Address: 14 Suffolk Avenue Batley WF17 7AN

Application number: 2021/93628	
What is the application for?:	Erection of single storey front and two storey side and rear extensions and exte
Address of the site or building:	16, Suffolk Avenue, Staincliffe, Batley, WF17 7AN
Postcode:	WF17 7AN

PROPOSED FRONT ELEVATION
SCALE 1:100 @ A3

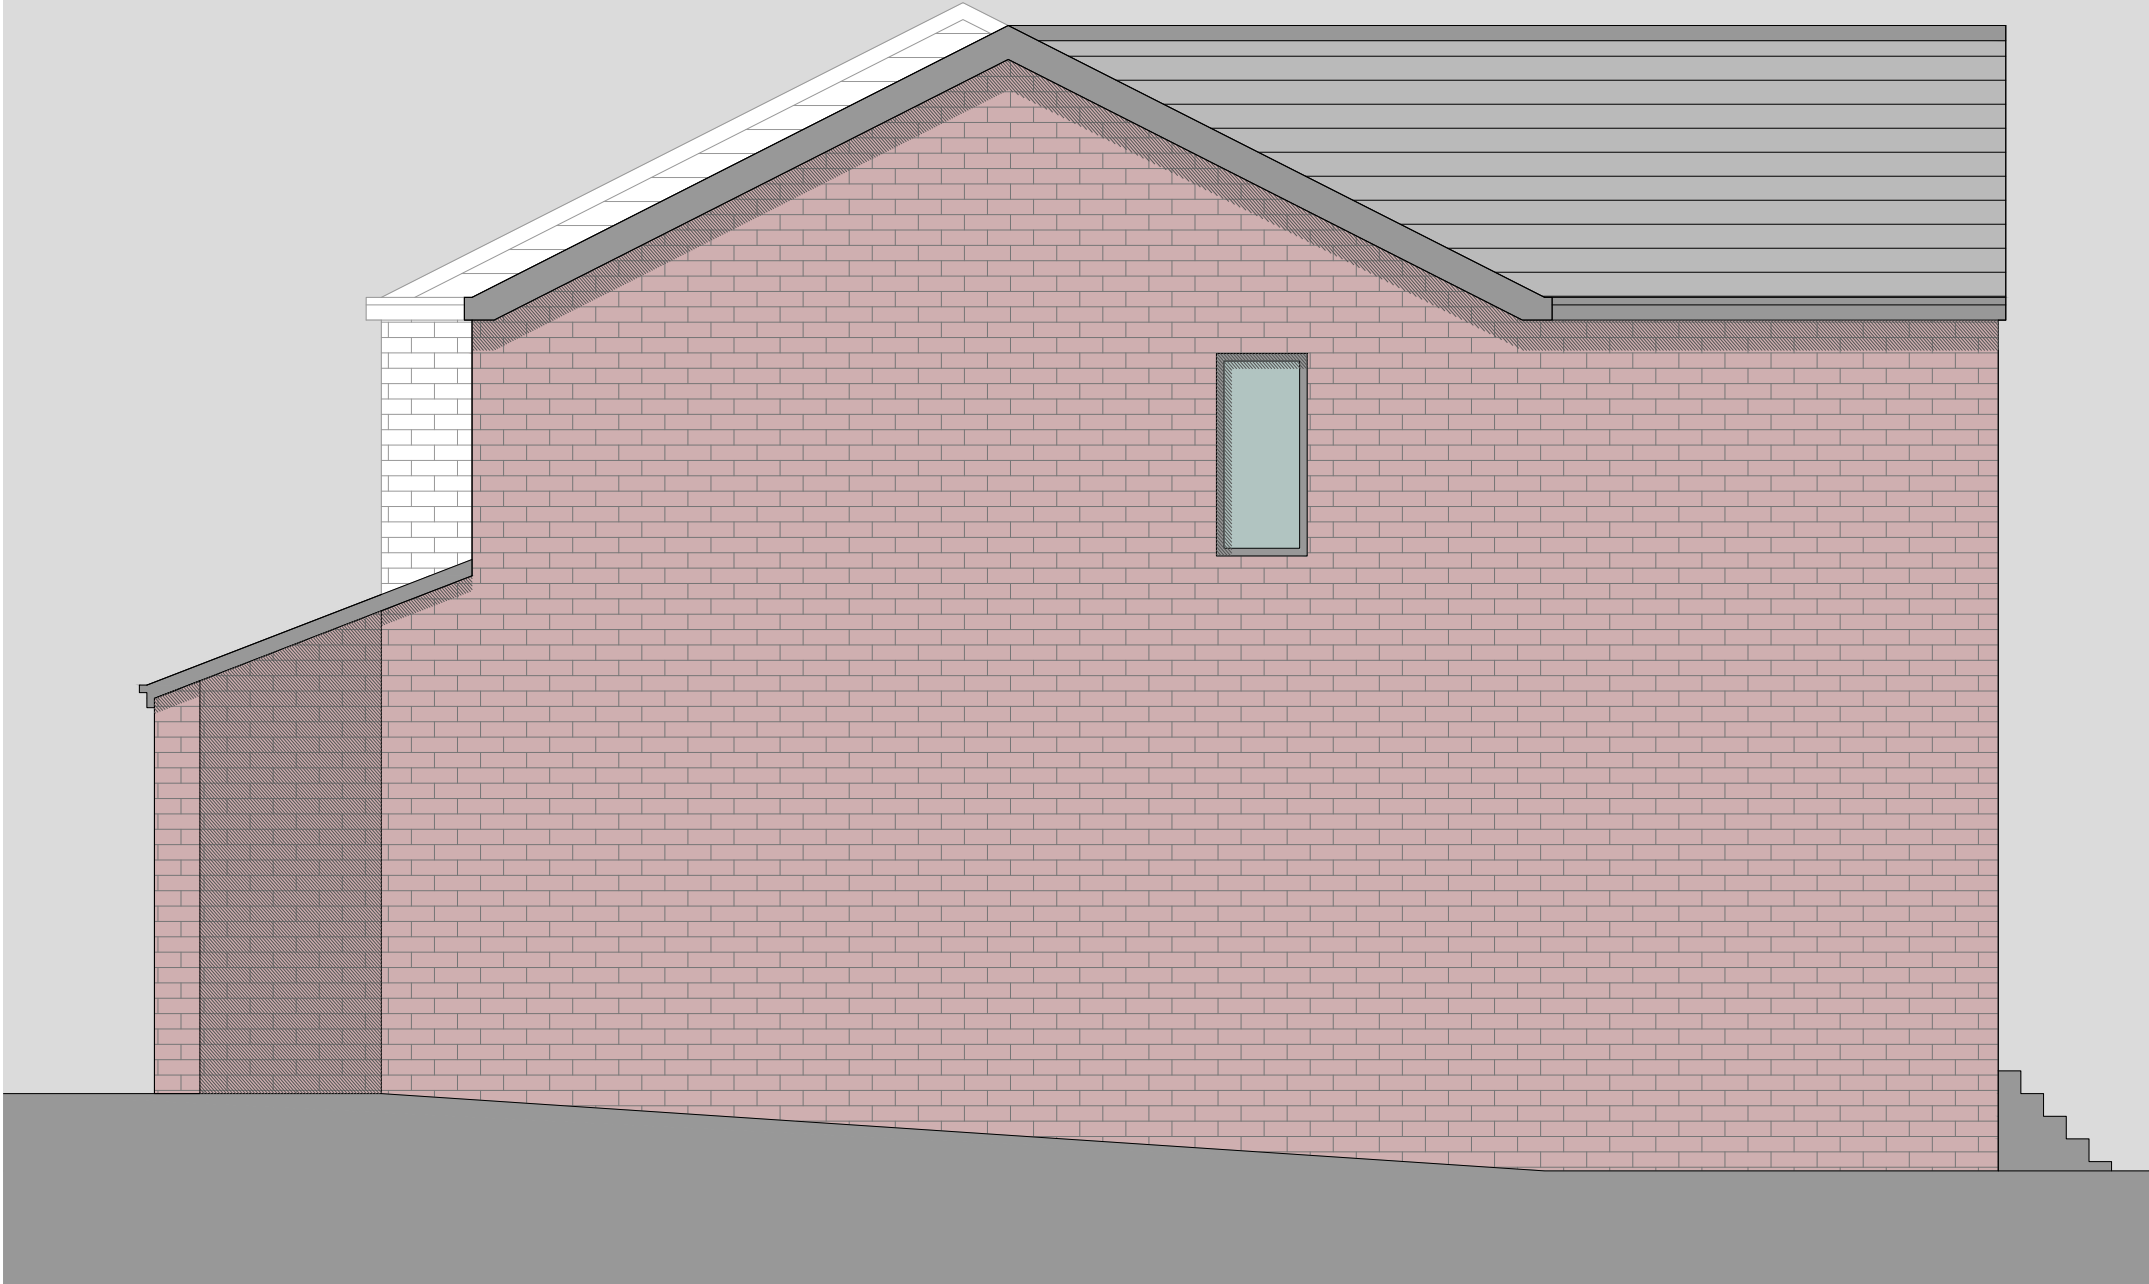
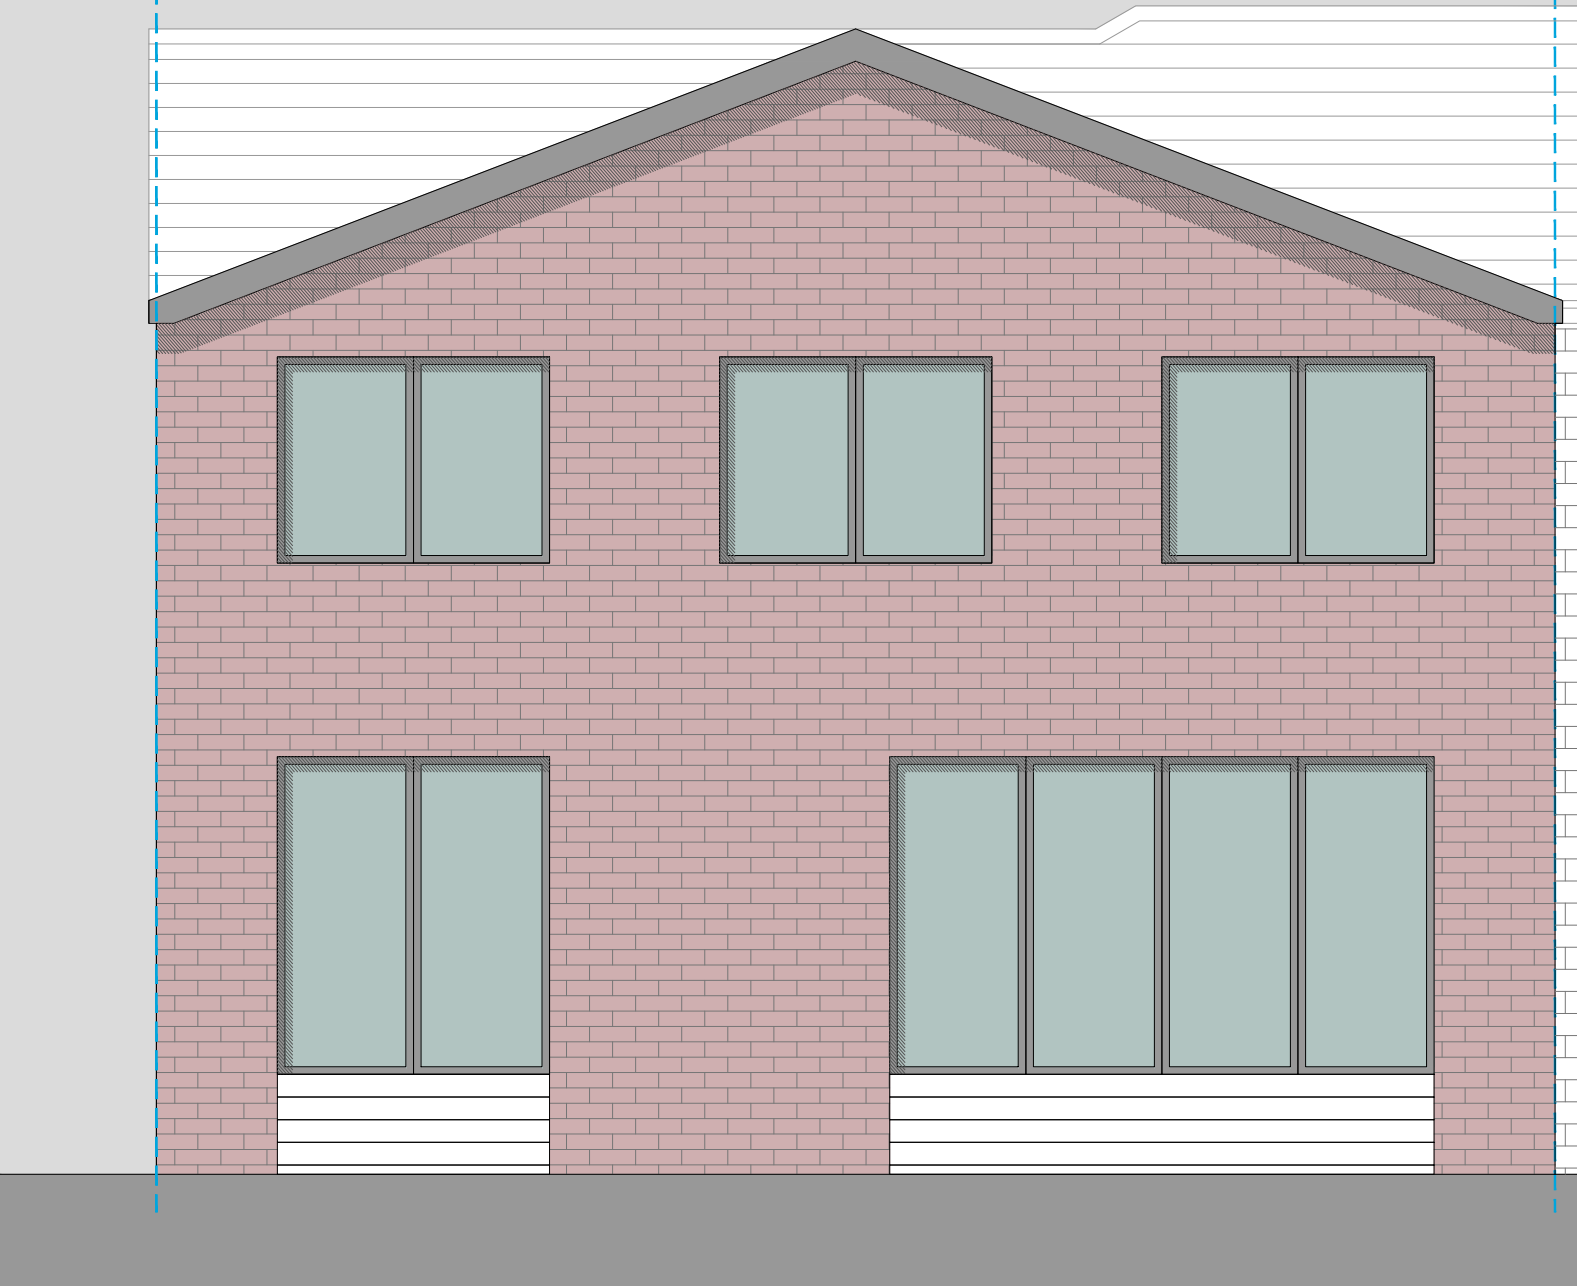
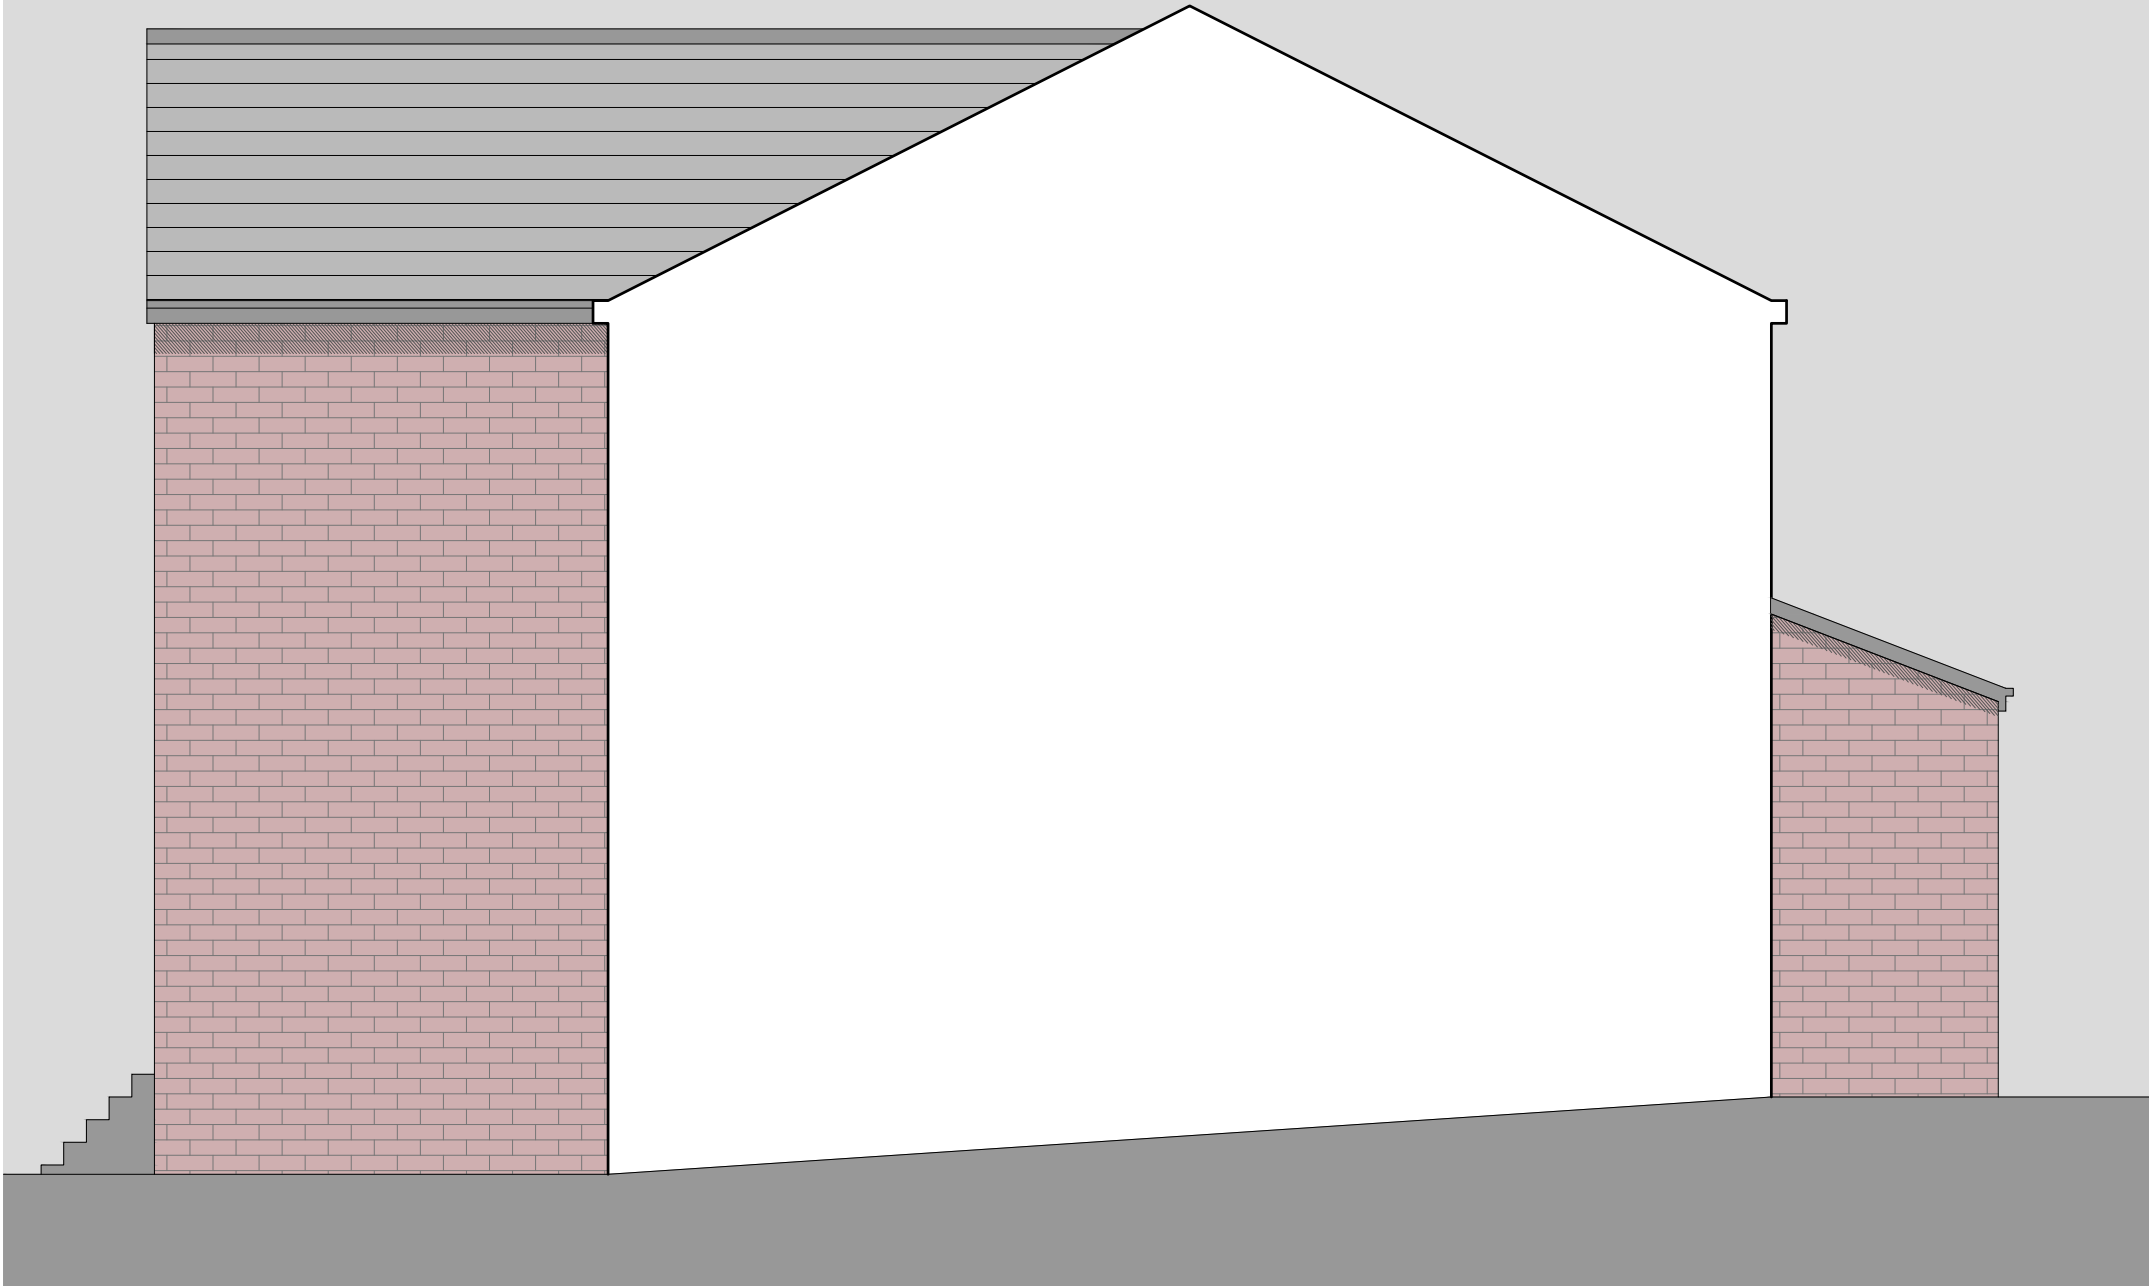
Type of comment: An objection	
Do you wish your comments to be published on the website anonymously?	No
I have an objection to the plans that have been submitted, the objection is regarding the erection of single storey front. The property will be completely different to the rest of the houses in the street - all houses have a bay window at the front and this property will not. My main objection is that if this extension is done then sunlight/daylight will be restricted into our front room, also privacy will be an issue as the neighbours front window will be looking into our front room and our view will be their extension. In the future if we decided to sell our home, I believe my home value will be affected negatively as the frontage will be uneven and odd looking semi-detached house. Please kindly consider my objection and await your comments.
